PLANNING APPLICATION CONSULTATION RESPONSE

Application Number:	3/2024/0060
Proposal:	Approval of details reserved by conditions 7 (Construction Traffic Management Plan) and 15 (Construction Surface Water Management Plan) of planning permission 3/2023/0305.
Location:	Land at former Higher Standen Farm (adj Swardean Way Valley Lane Higher Peak Crescent South Gate Broadfield Street) Pendle Road Clitheroe BB7 1PR

The Lead Local Flood Authority is currently **unable to recommend the discharge of condition 15** on planning decision 3/2023/0305 on the basis of:

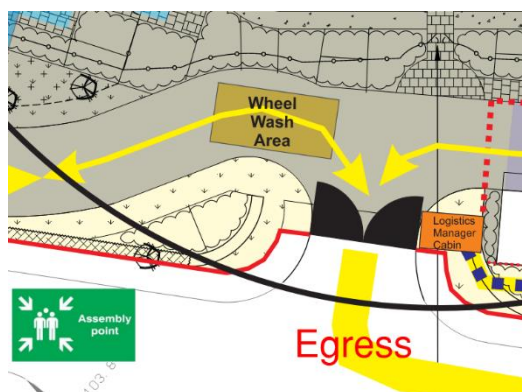
- The applicant has failed to provide sufficient information to demonstrate how surface water and pollution and prevention will be managed during the construction phase. The Lead Local Flood Authority acknowledges, the applicant's reference to installing the site drainage as soon as possible, however this does not address how surface water and pollution prevention will be managed appropriately in the interim period before the drainage system has been fully implemented. In addition to this

the applicants mention of discharging to the foul sewer, fails to demonstrate the area of that surface water will be held in prior to discharge and at what rate, the applicant should also seek guidance from United Utilities given the proposal to discharge surface water to a foul sewer.
